**WEST SUSSEX COUNTY COUNCIL
PLANNING SERVICES CONSULTATION**

SUBJECT: A/176/17/PROW - 2 No. dwellings. This application affects a Public Right of Way.

Land between Badgers & Ashurst Ham, Manor Way, Angmering

Please accept the following comments on behalf of PROW (Public Rights of Way) regarding the above planning application – A/176/17/PROW

Site Plan (1:200)

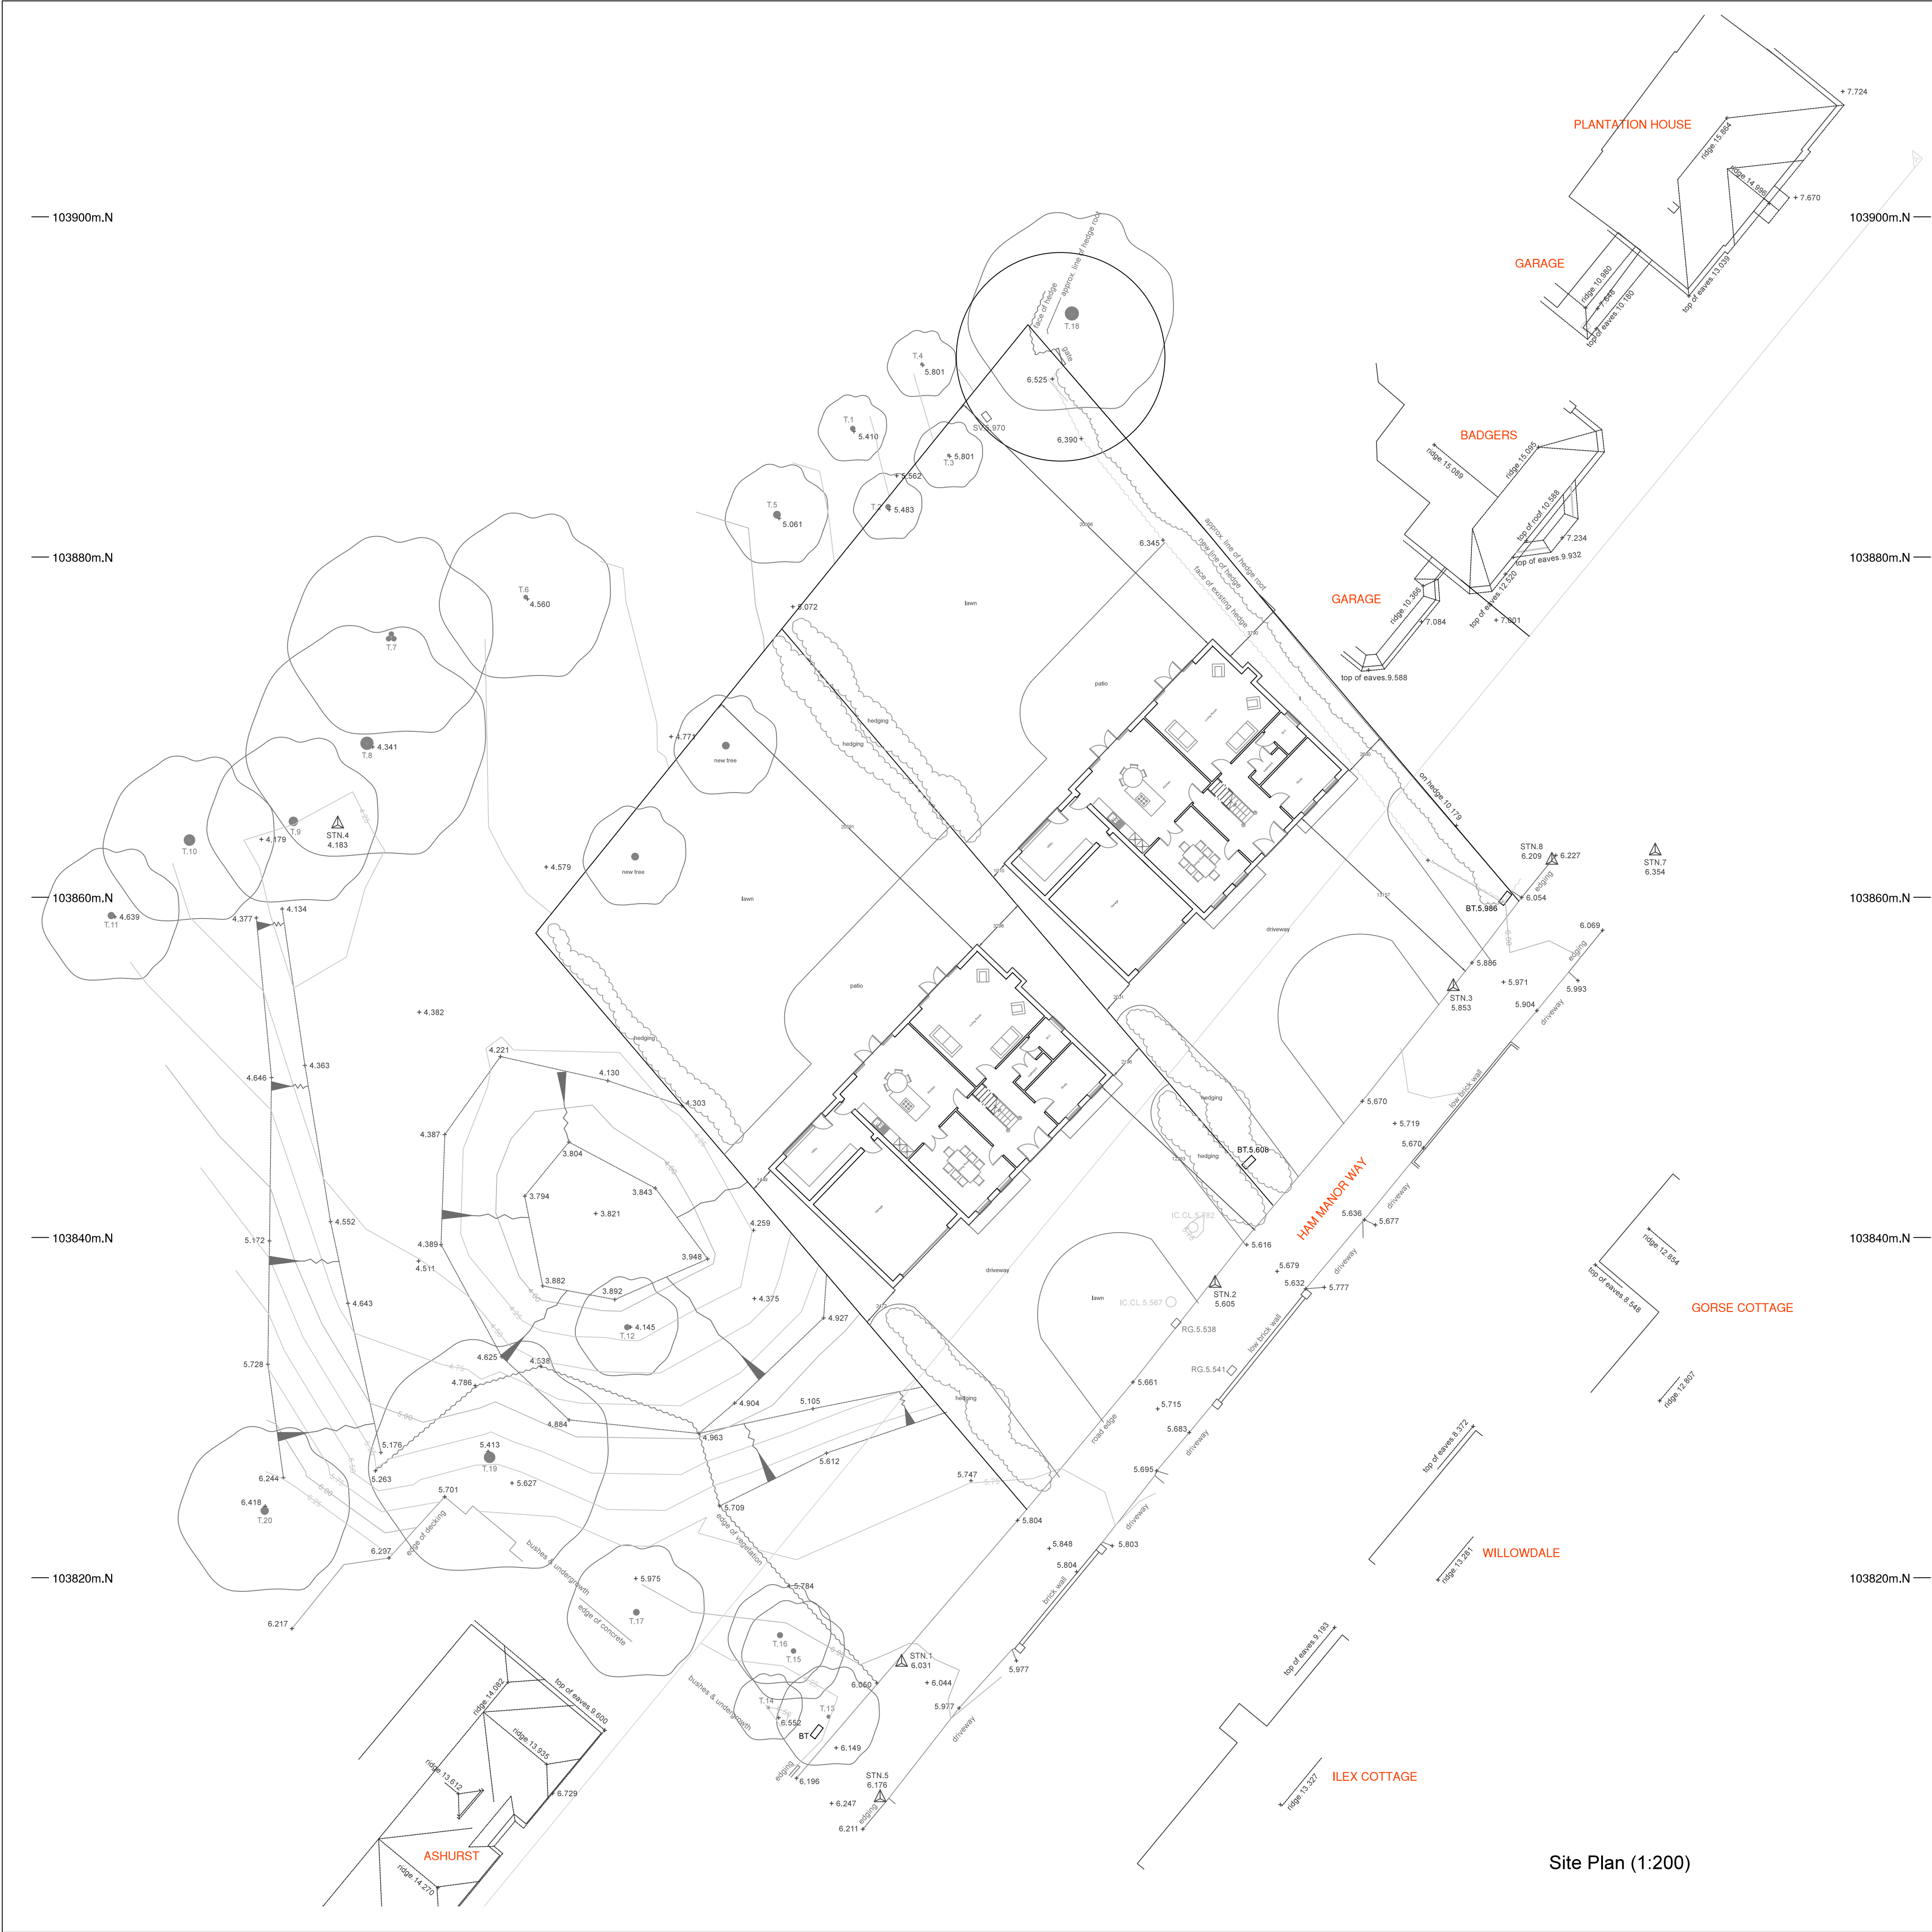
Ham Manor Way, FP2195, is used for vehicular access to existing houses and for the proposed development. As the applicant's main site plan, 1131.02a does not show any adverse effect to the footpath and there are no plans to realign the route we would have no objection to this application as long as the following comments and guidance are followed:

At no stage can this footpath (the entire width of the road) be restricted or obstructed and any vehicles using this route should give way to lawful path users as the pedestrian right of access takes precedent over any private rights of vehicular access.

While the development is underway, safe & convenient public access is to be available at all times across the full width FP2195 and the route cannot be obstructed by vehicles, plant, scaffolding or the temporary storage of materials and/or chemicals during any works.

Any alteration to, or replacement of, the existing boundary with the PROW or the erection of new fence lines, must be done in consultation with WSCC's PRow Team to ensure the legal width of the footpath is maintained and there is no unlawful encroachment. Should planning consent be approved by the Local Planning Authority this would not confer consent for such fencing of the PROW, which would require a separate application to WSCC's RoW Team.

Any down pipes or soakaways associated with the development should discharge into an existing or new drainage system and away from the surface of the PROW. No drainage system is to be installed through the surface of the path without the prior consent of WSCC's PRow team.
